**Consultation Response from KC,
Highways Development Management**

2026/90857 HSBC, 2, Cloth Hall Street, Huddersfield, HD1 2EG

Date Responded: 04/06/2026

Responding Ref: K5-7NW/31

**SIXTH FLOOR PLAN - PLANT ROOM
TO REMAIN UNALTERED**

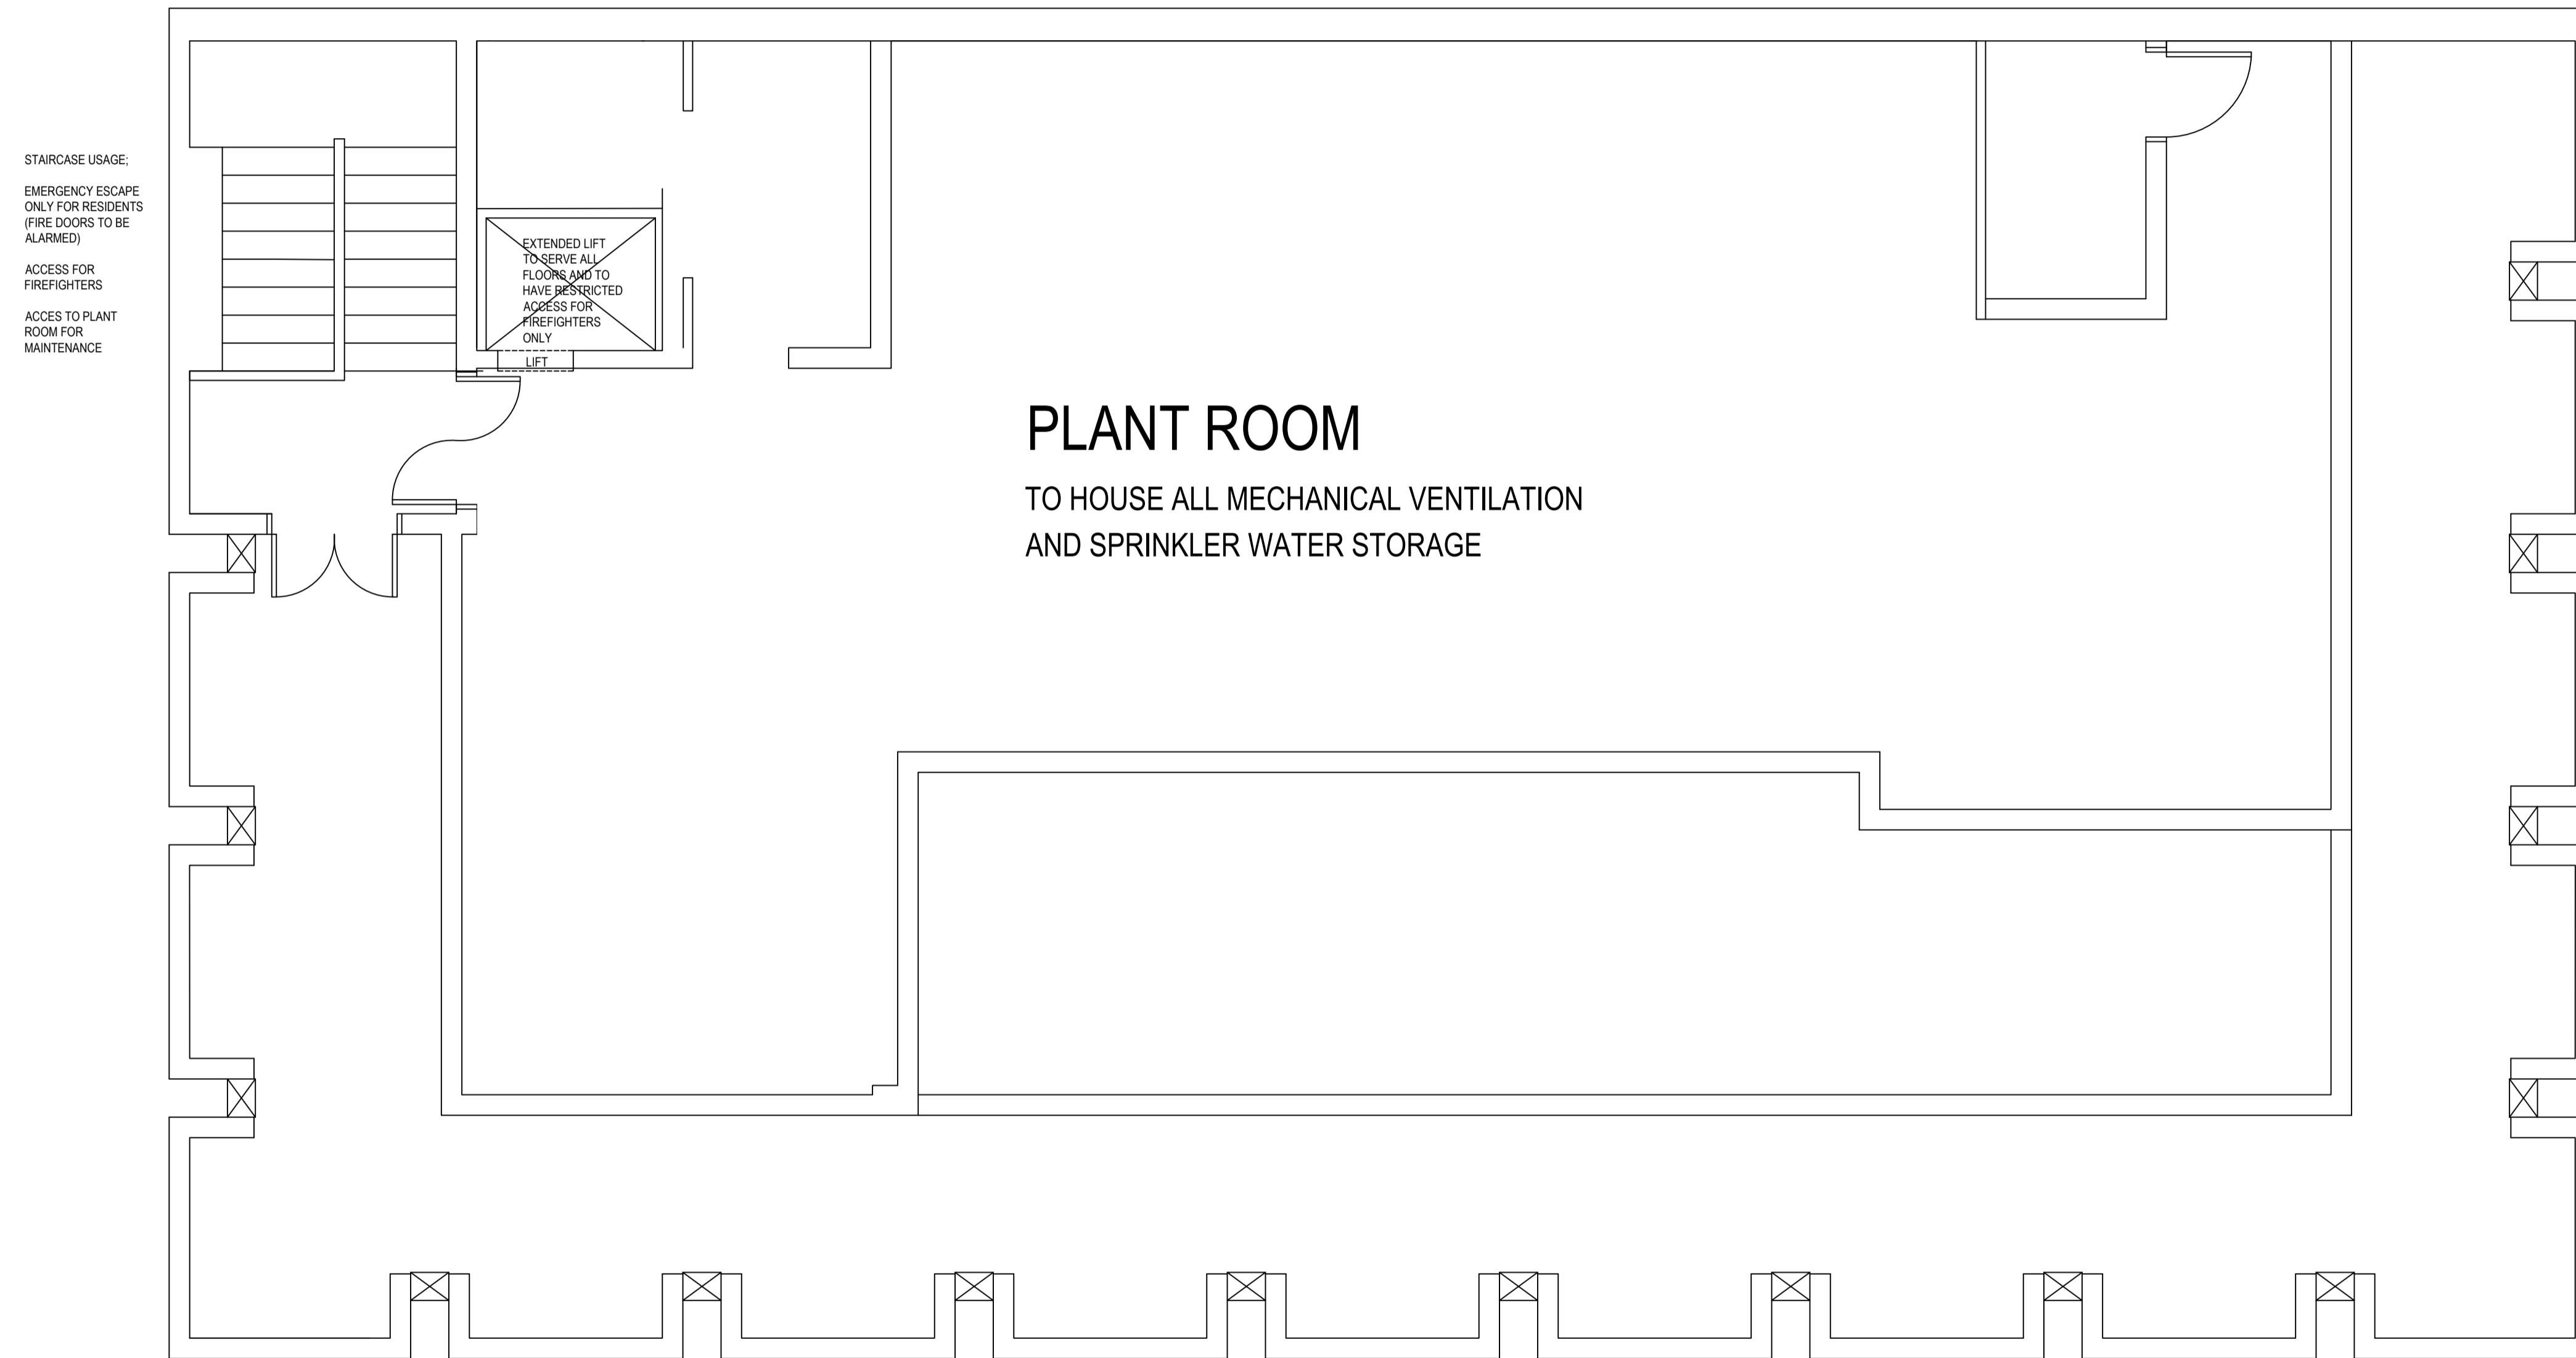
The changes to the sixth floor are to remove the plant room and replace this with an office and a communal space for the residents accessed via a new stairway and the existing lift. These changes would not have an impact on the surrounding highway or highway safety and are therefore acceptable on highways grounds.

GROUND FLOOR PLAN

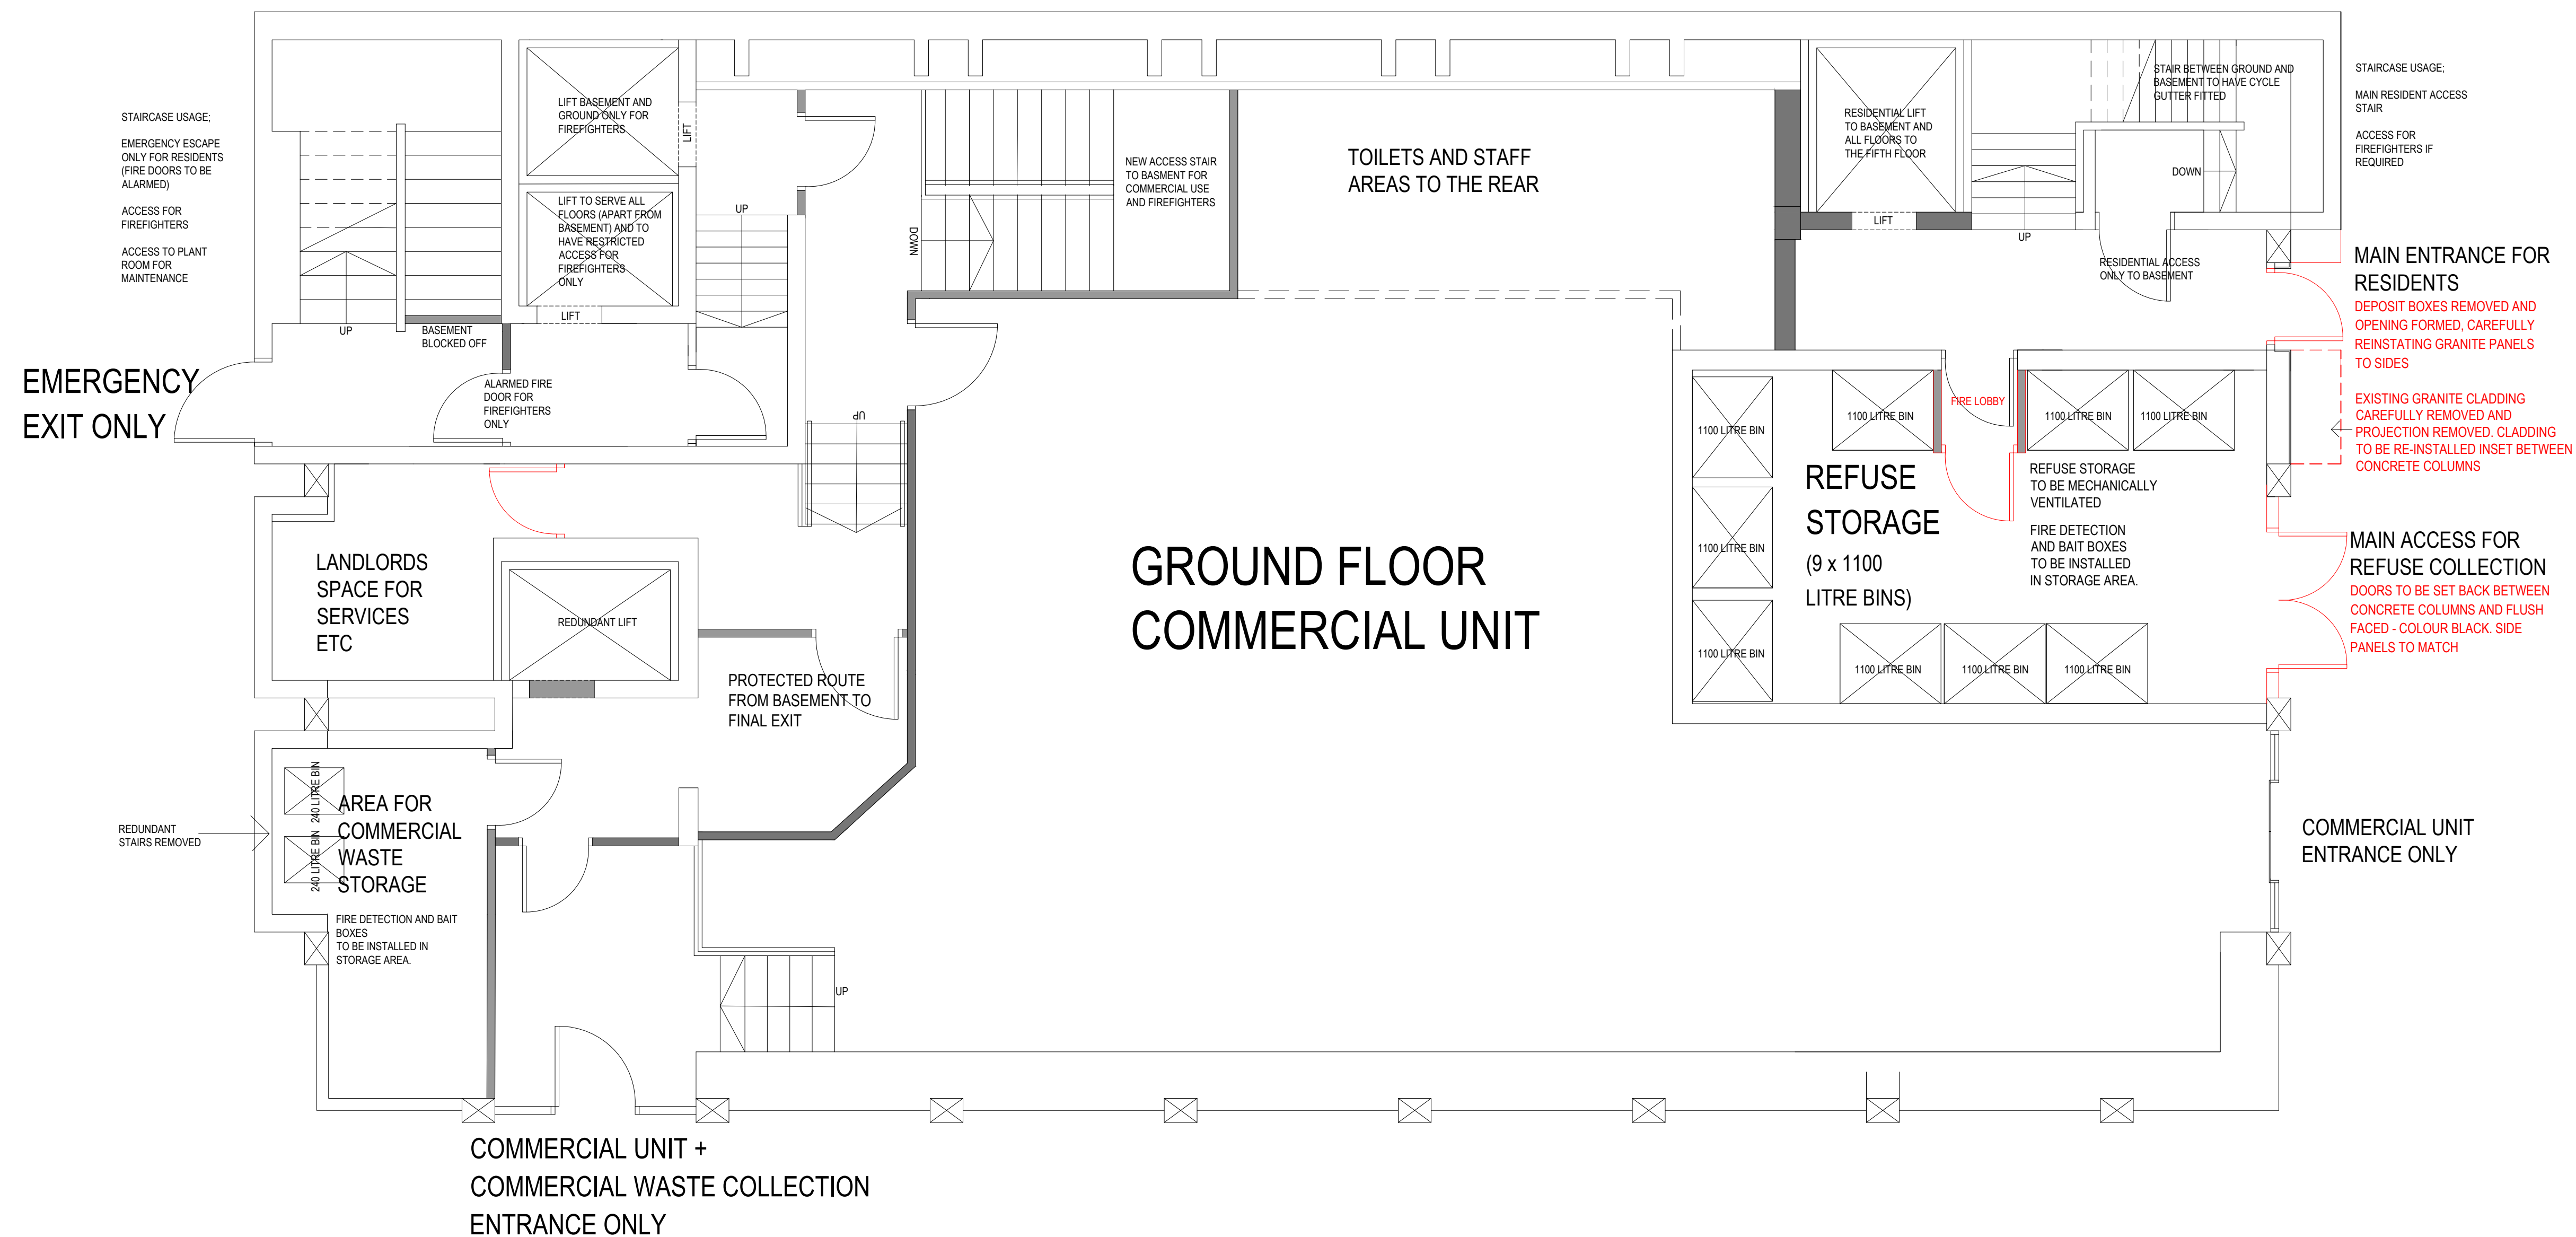
There are to be no changes to the basement and floors 1 to 5 and these will remain as approved in previous permission 25/91221. The changes to the ground floor are to relocate the bin storage room to allow access to the commercial use from New Street and the creation of two new access points fronting on to New Street for the refuse access and the residential access. Previously the commercial use only had an access on to Cloth Hall Street and the waste and residential access on to New Street was shared between these two uses.

The proposals for the changes to the ground floor will not be expected to have any adverse impact on the highway and as such these are acceptable on highways grounds.
